# **CHATBURN PARISH COUNCIL**

18 April 2019

**Planning Application No. 3/2019/0091 – Greendale View, Downham Road**

SHEET:
SITE PLAN

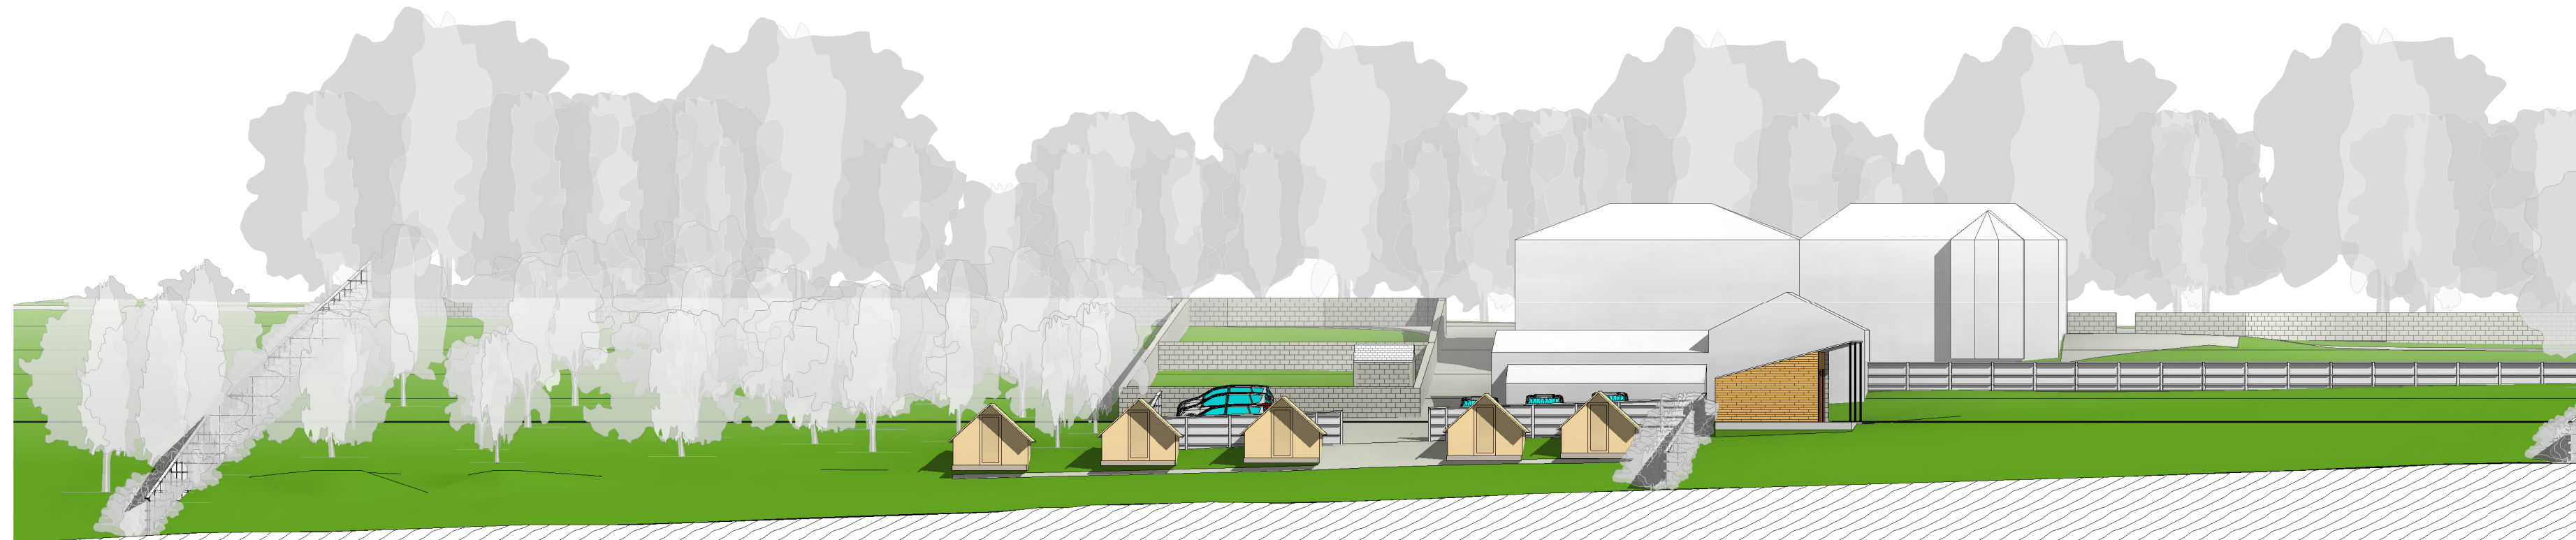
Chatburn Parish Council has viewed the above planning application and is concerned about the access to and from the property on to a narrow and extremely busy road. The visibility is poor and there is no footpath for pedestrians.
